**Planning Department
Transportation Development Services**

October 7, 2015

Re: Taco Bell Renovations
4815 4th St., NW
Traffic Circulation Layout
Engineer's/Architect's Stamp dated 9-4-15 (F14-D071)

TACO BELL

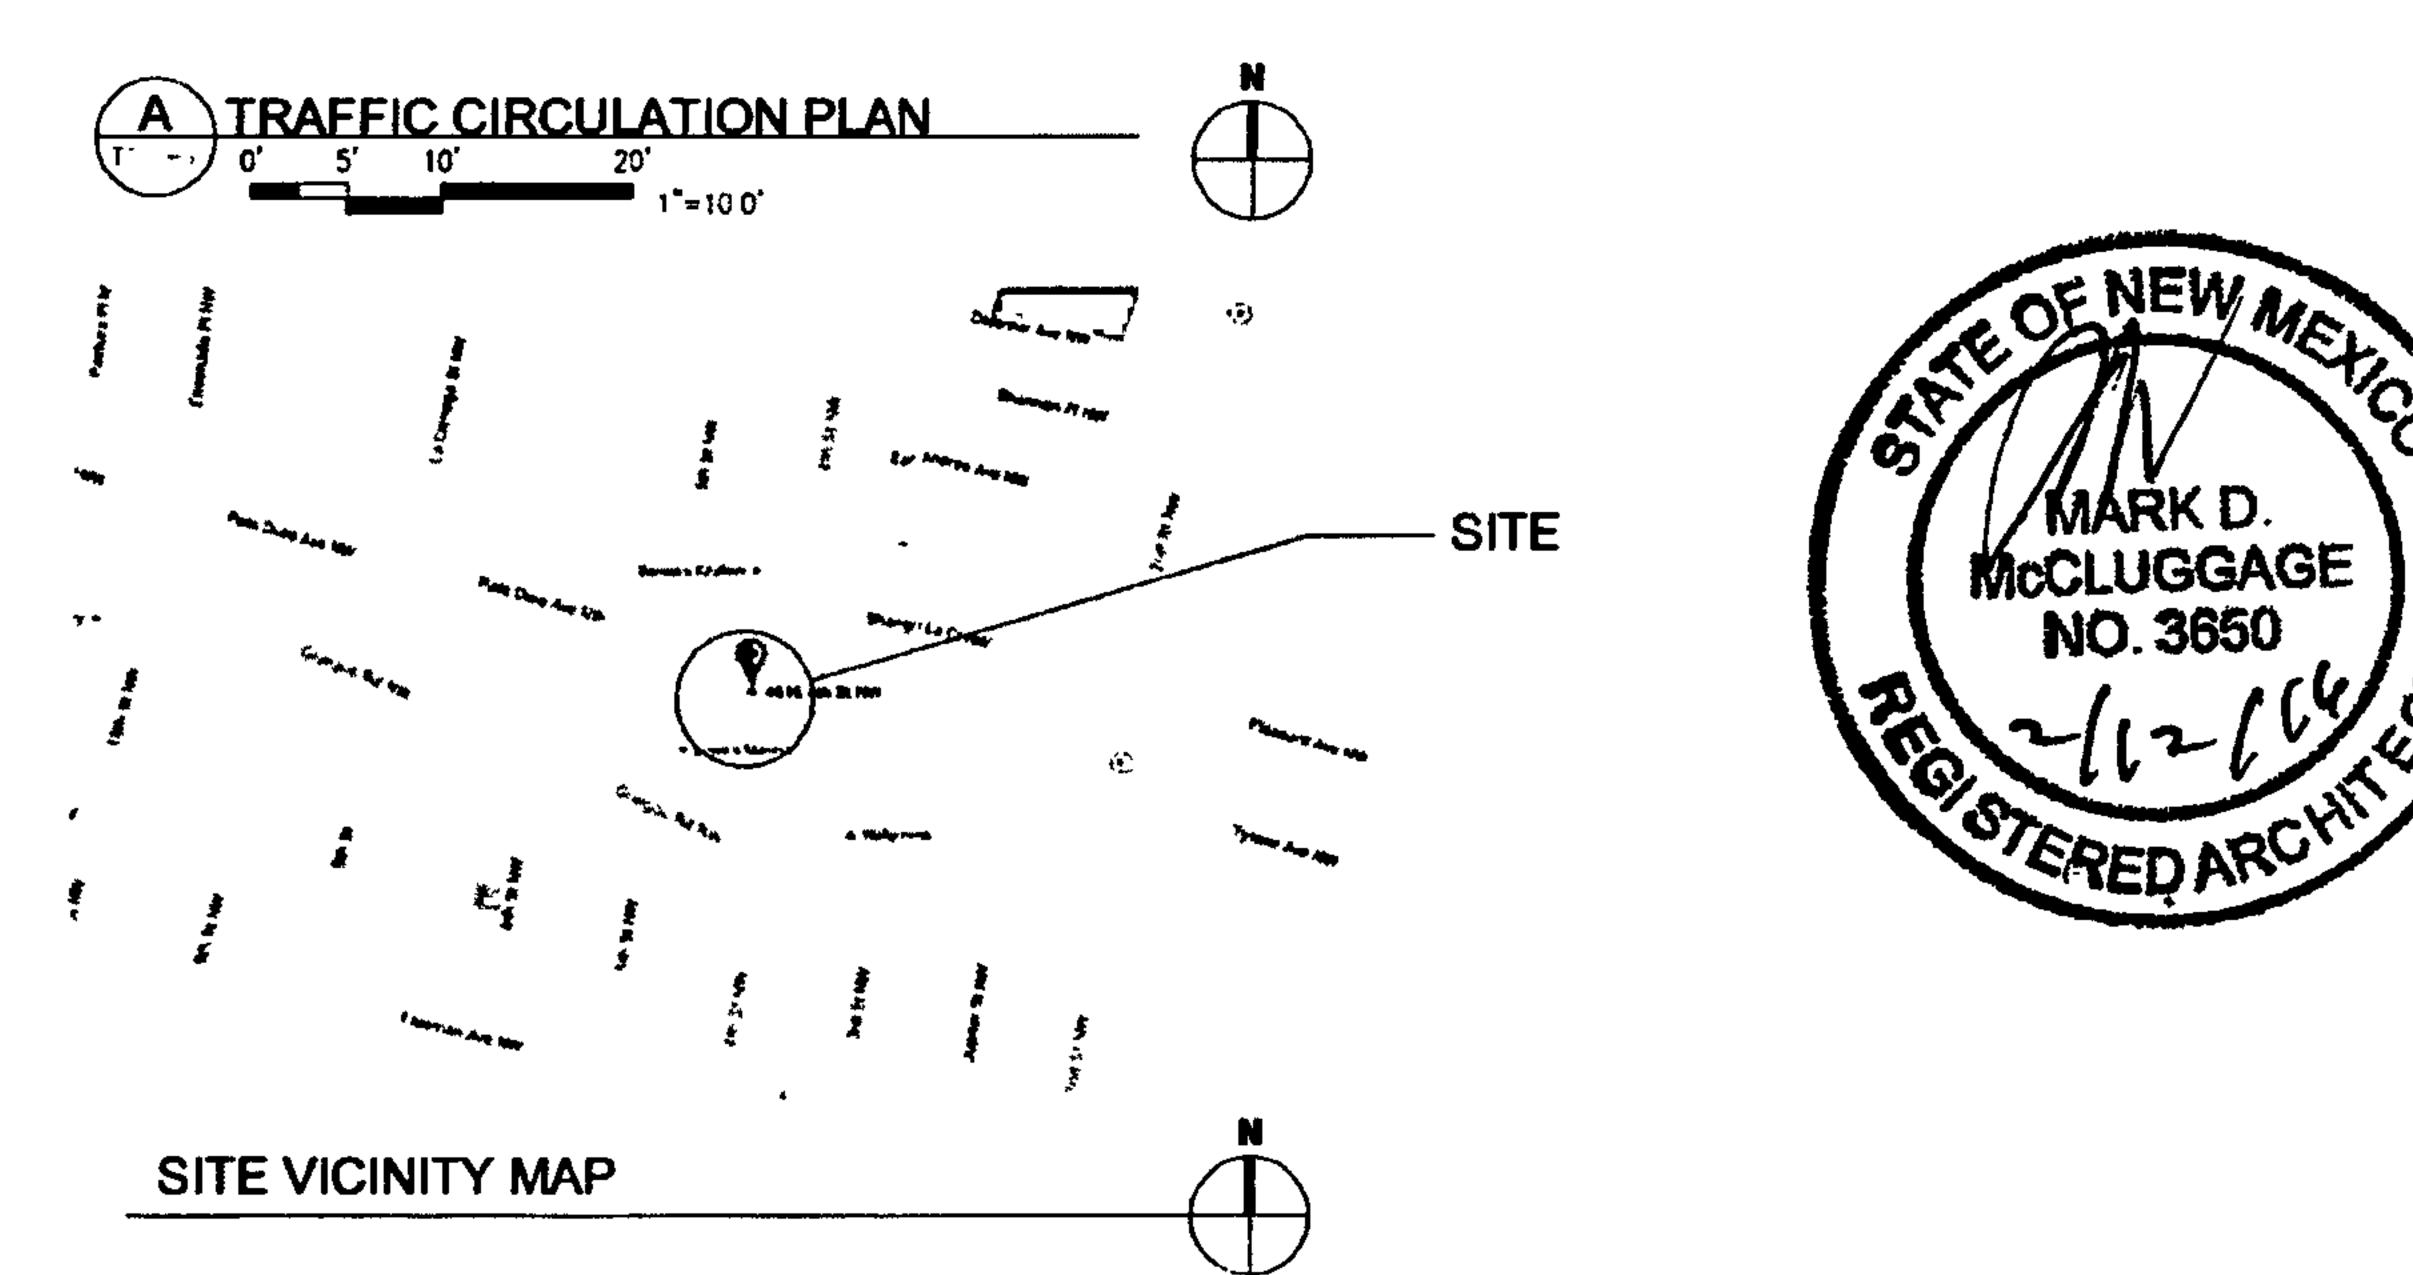
1. Please show a vicinity map showing the location of the development in relation to streets and well known landmarks.
2. List the number of parking spaces required by the zoning code as well as the proposed number of parking spaces. Please include the number of required handicap parking spaces.

3. Please identify all existing buildings, doors, structures, sidewalks, curbs, drive pads, walls and anything that influences the parking and circulation on the site.

4. Identify all existing access easements and rights of way with dimensions.
5. Identify the right of way width, medians, curb cuts, and street widths on 4th St. and Palo Duro Ave.

6. Please list the width and length for all parking spaces. Detail the overall length of all the diagonal parking spaces and overall drive isle widths.

7. Please detail the drive thru queuing length.
8. The handicap accessible spaces must include an 8-foot wide van access aisle; all other aisles should be 5 feet in width.

9. The ADA accessible parking sign must have the required language per 66-7-352.4C NMSA 1978 **"Violators Are Subject to a Fine and/or Towing."**
10. The ADA access aisle shall have the words **"NO PARKING"** in capital letters, each of which shall be at least one foot high and at least two inches wide, placed at the rear of the parking space so as to be close to where an adjacent vehicle's rear tire would be placed. (66-1-4.1.B NMSA 1978)

11. Per the DPM, a 6 ft. wide ADA accessible pedestrian pathway is required from the public sidewalk to the building entrances. Please clearly show this pathway and provide details from both 4th St. and Palo Duro Ave.
12. Per the DPM, a 6 ft. wide ADA accessible pedestrian pathway is required from the HC parking stall access aisles to the building entrances. Please clearly show this pathway from the handicap parking space.
13. Service vehicle and/or refuse vehicle maneuvering must be contained on-site; provide a copy of refuse approval.
14. Please provide a sight distance exhibit (see the *Development Process Manual, Chapter 23, Section 3, Part D.5 Intersection Sight Distance*) for both 4th St. and Palo Duro Ave.

15. Please add the following note to the clear sight triangle: "Landscaping and signage will not interfere with clear sight requirements. Therefore, signs, walls, trees, and shrubbery between 3 and 8 feet tall (as measured from the gutter pan) will not be acceptable in this area."
16. Please include two copies of the traffic circulation layout at the next submittal.
